Our Ref: PREAPP/20/00082

**TOWN AND COUNTRY PLANNING ACT 1990
Town and Country Planning (Development Management Procedure) (England) Order 2015**

PLANNING REFERENCE:	PREAPP/20/00082
DEVELOPMENT PROPOSED:	Re-development of site to provide an additional 8 touring caravan pitches and a erection of a holiday let to replace a residential outbuilding
LOCATION:	Adbo Hill, Tern Hill, Market Drayton, Shropshire, TF9 2JF.

Drawing Title: **ALIGNMENT PROPOSALS**

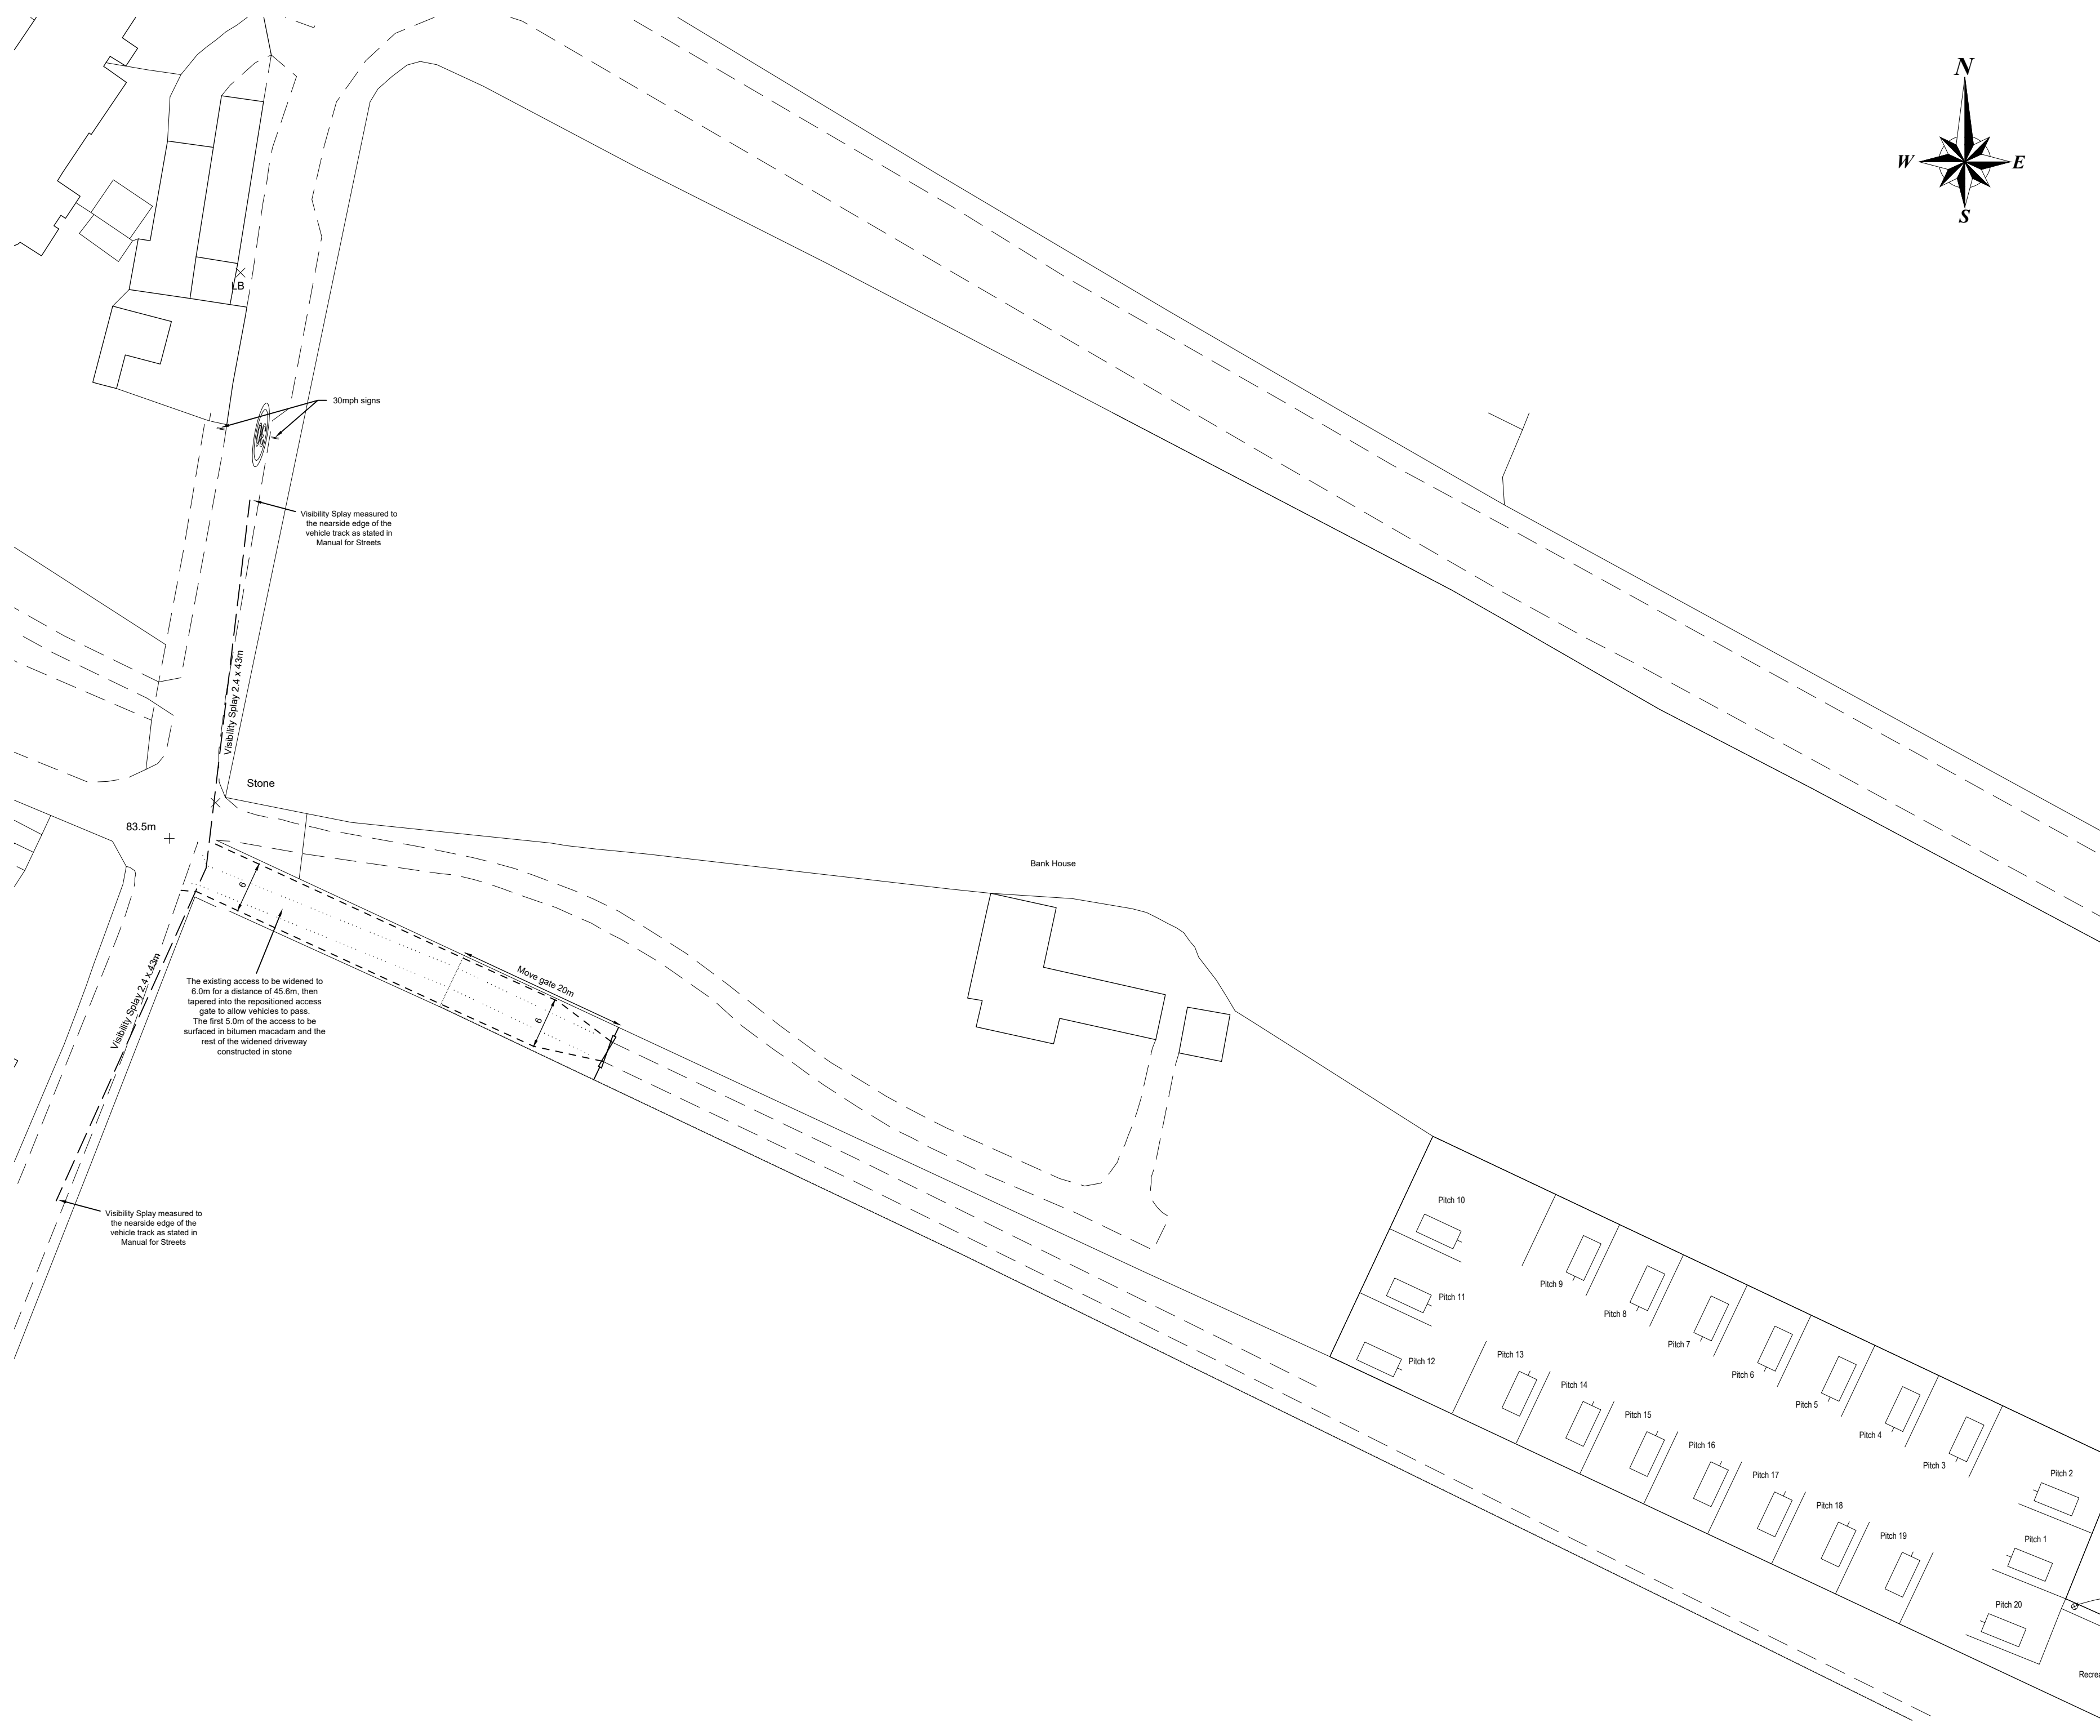
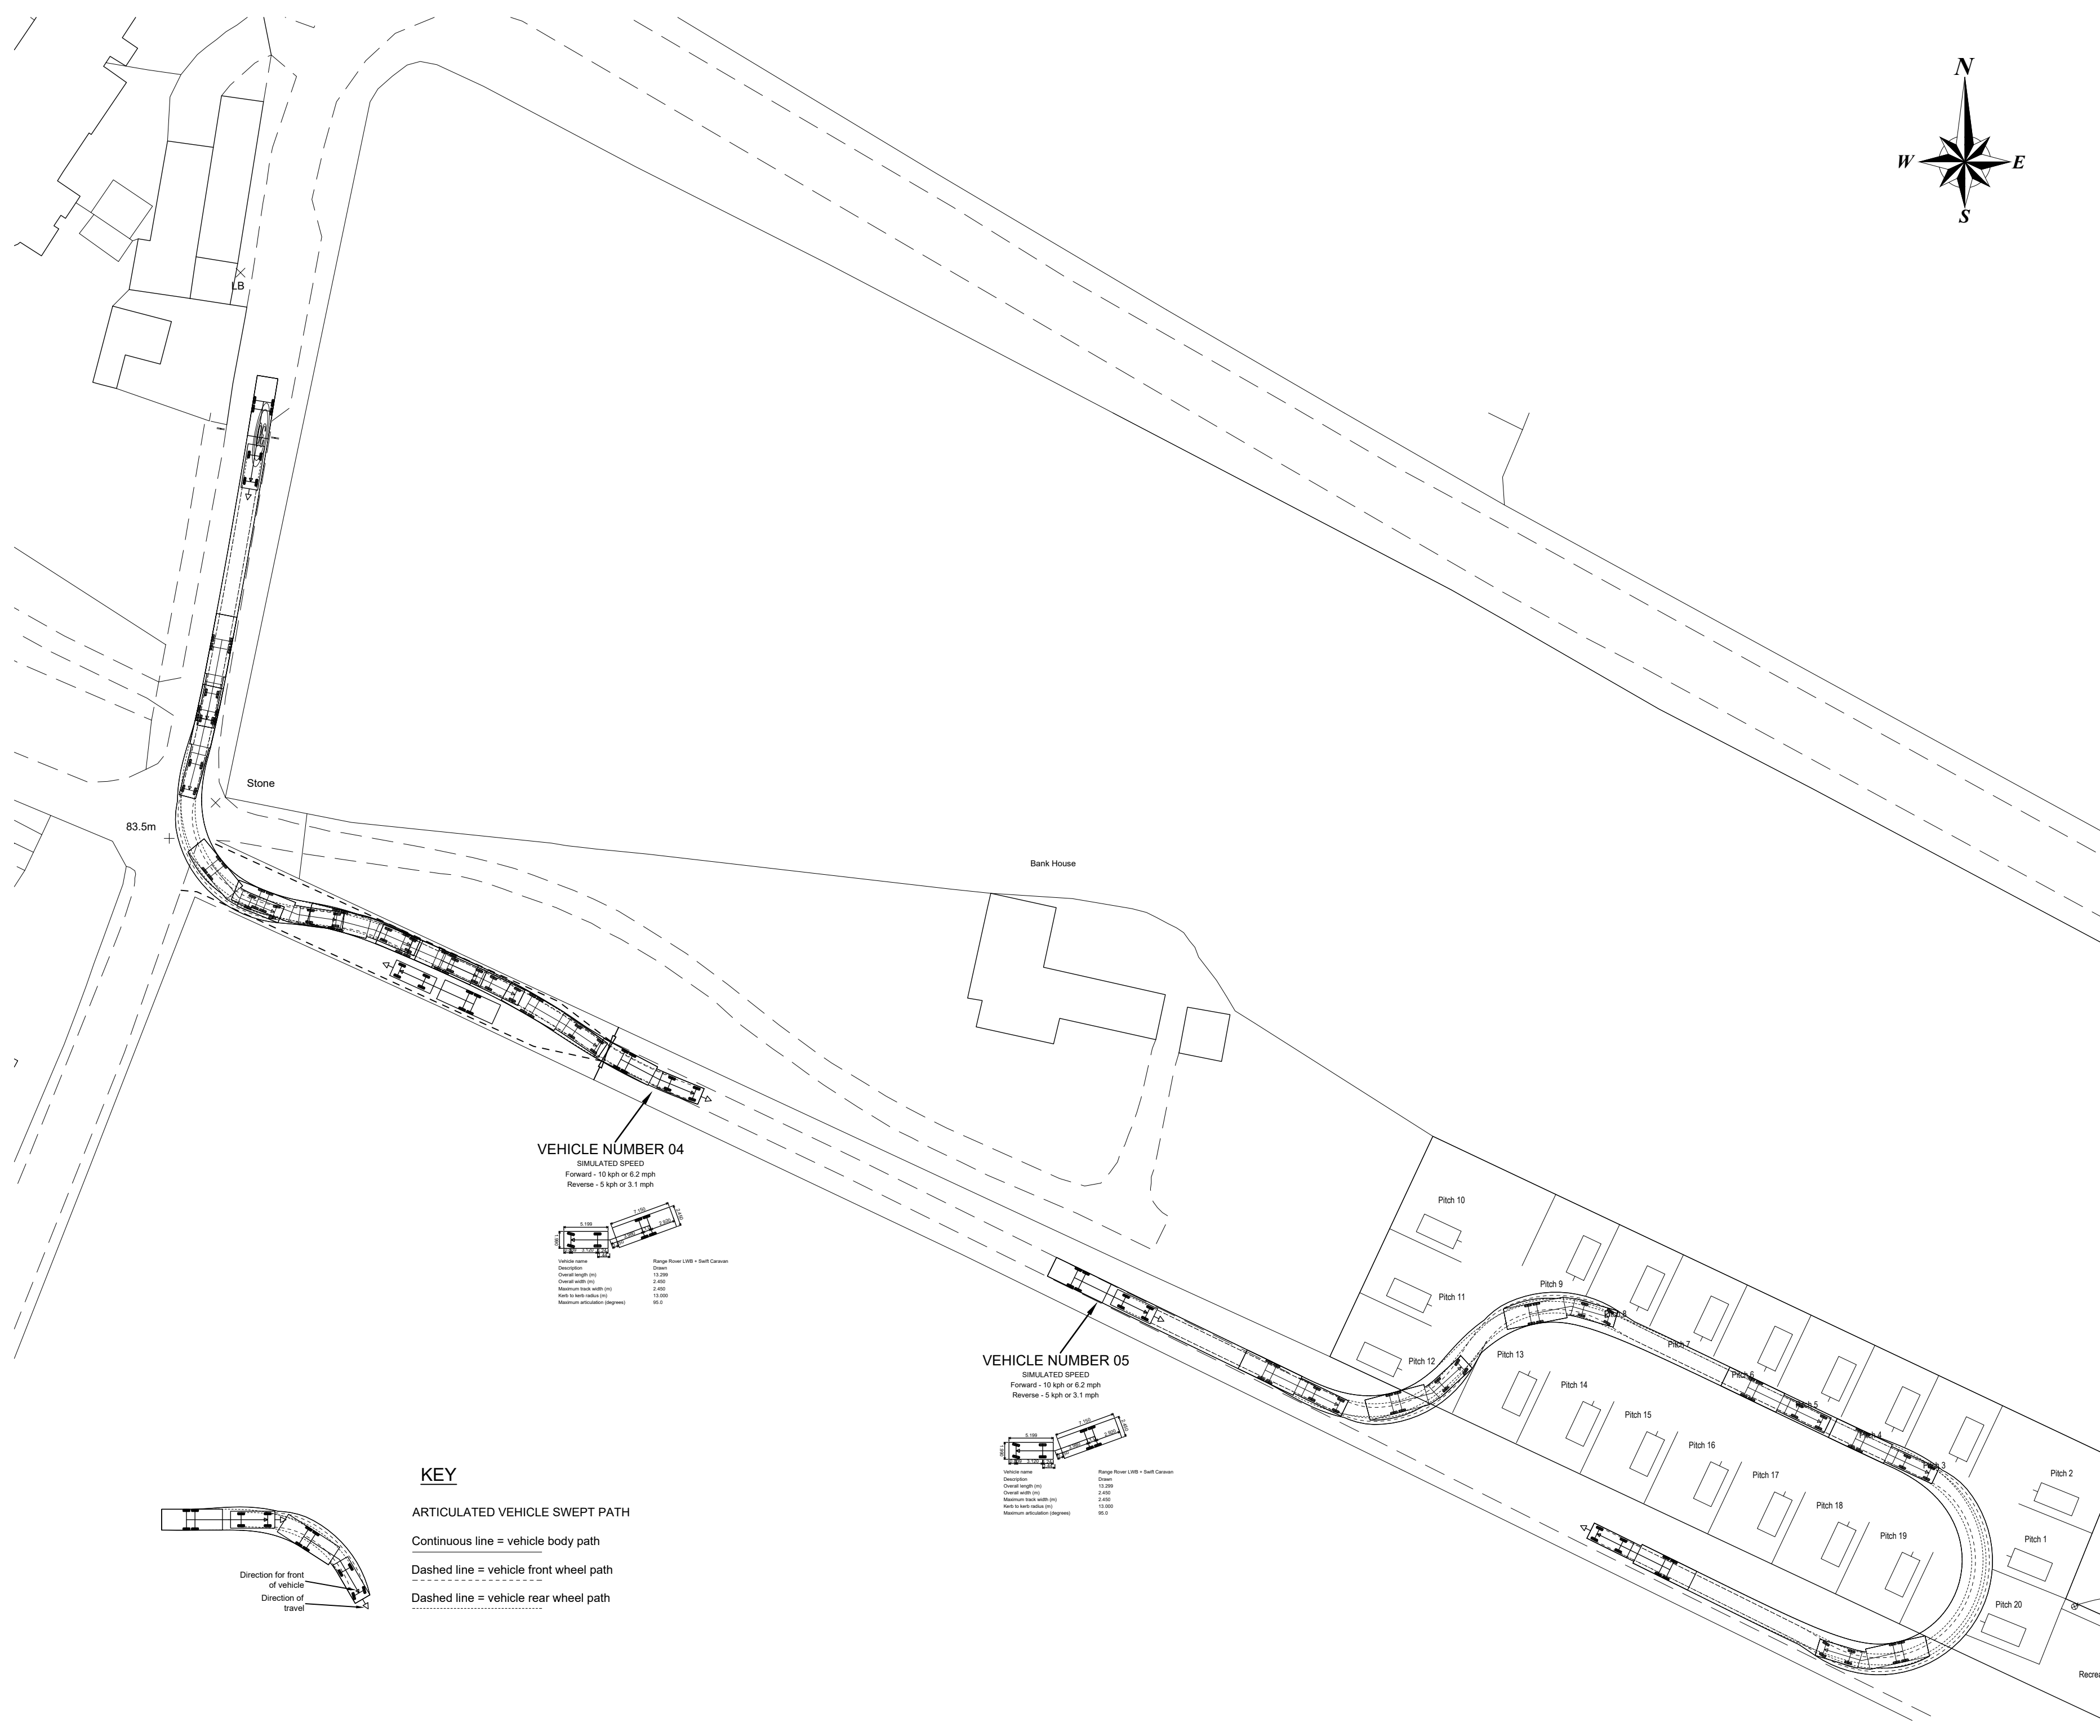
- o Detailed layout of the site entrance geometry, including visibility splays commensurate with prevailing highway conditions. Simultaneous entry and exit into the site should be demonstrated. Swept Path analysis diagrams could be considered.
